H09-0784-21 – LAND OFF FEN ROAD, HOLBEACH, SPALDING. RESPONSE TO CONSULTEE COMMENTS.

Please find below response to consultee comments on the planning application, H09-0784-21, Land Off Fen Road, Holbeach, Spalding.

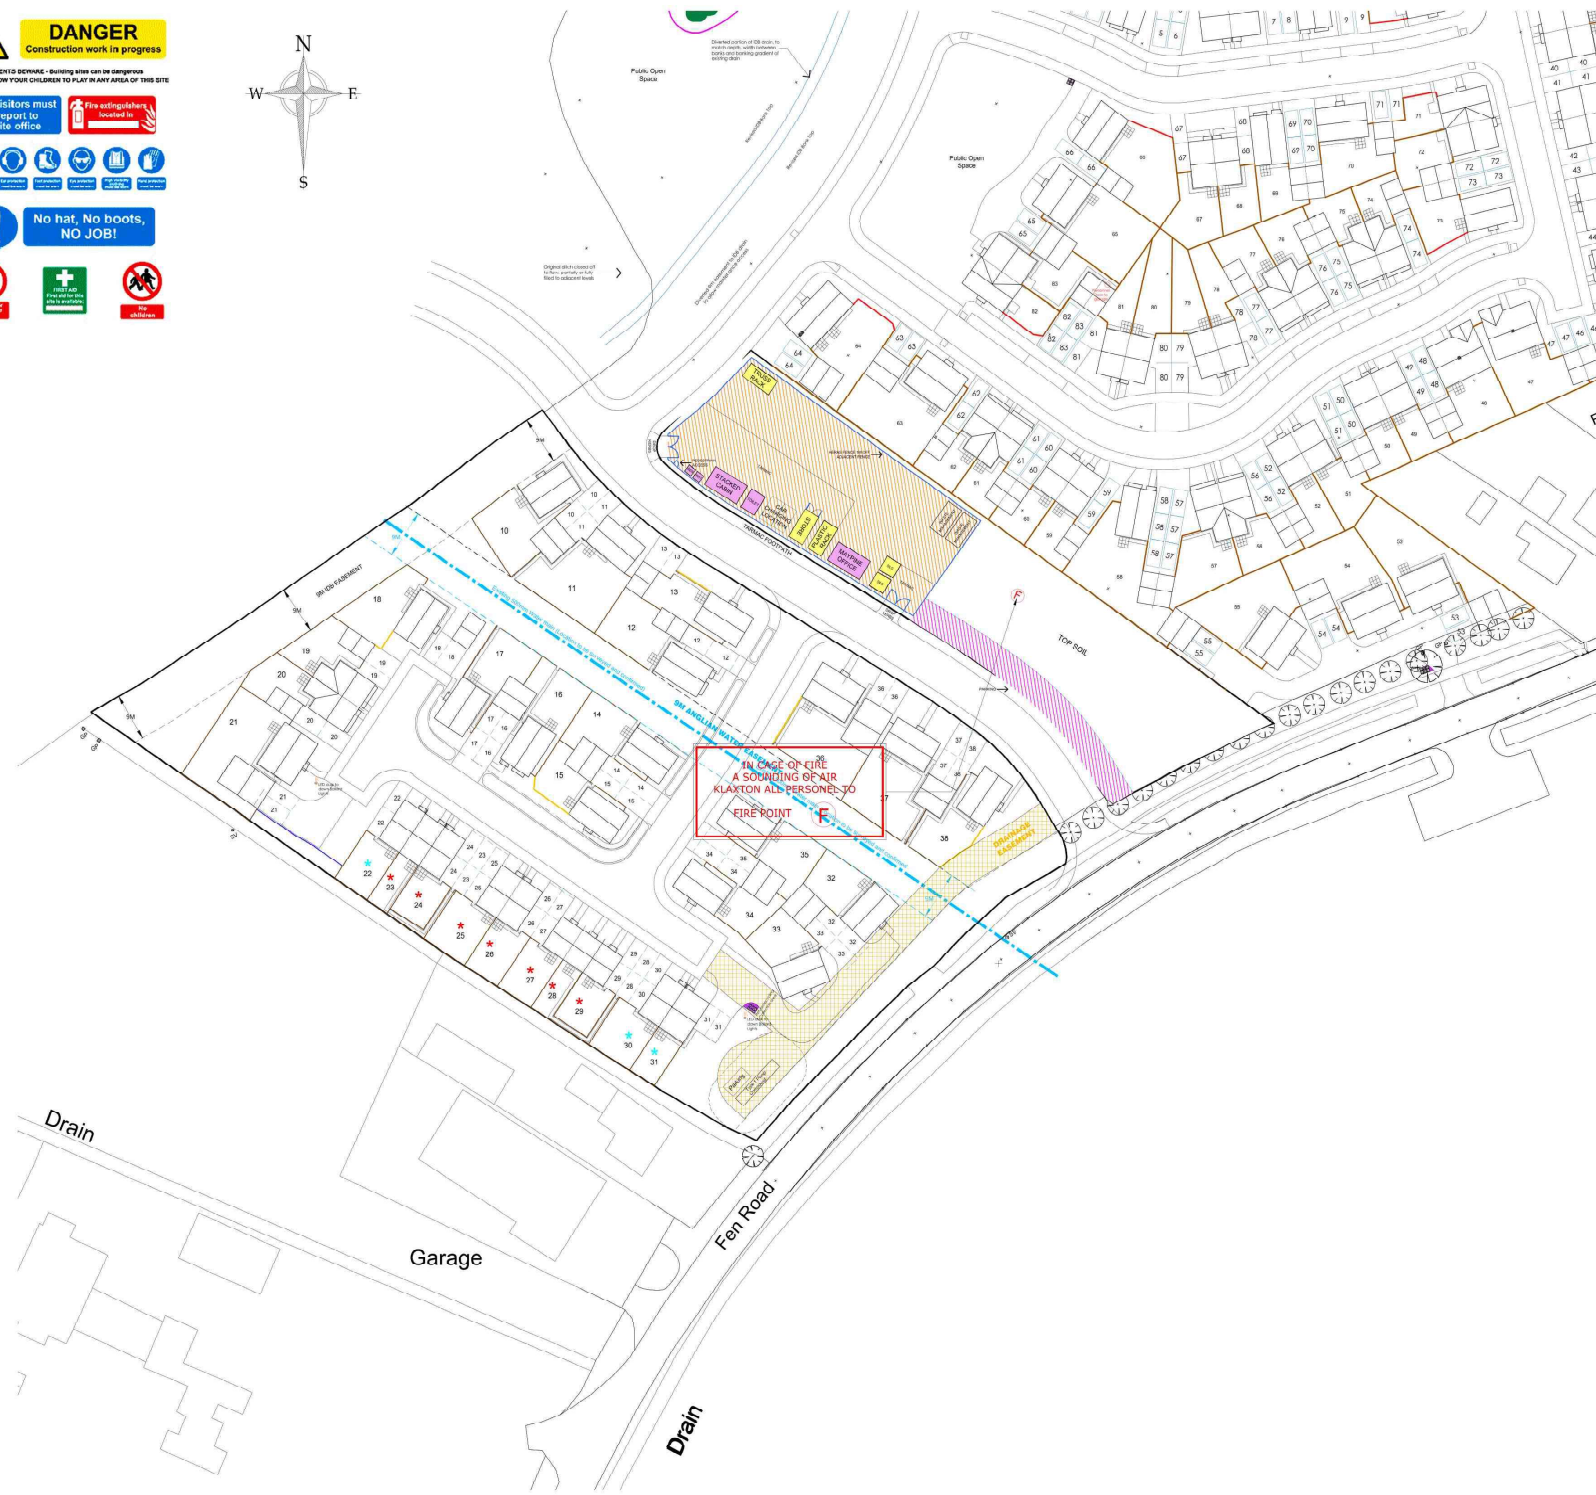
LCC HIGHWAY COMMENTS – RECEIVED 19/08/21

Further to the comments raised in respect of requesting additional information, please find accompanying this letter the following drawings: -

- 127 - S38 - 01 REV.B - S38 ADOPTABLE AREAS
- 127 - S38 - 02 - REV.B - EXCEEDANCE PLAN
- 127 - S38 - 03 - REV.B - FINISHED FLOOR LEVELS
- 127 - CMP - 01 - CONSTRUCTION MANAGEMENT PLAN
- CONSTRUCTION METHOD STATEMENT
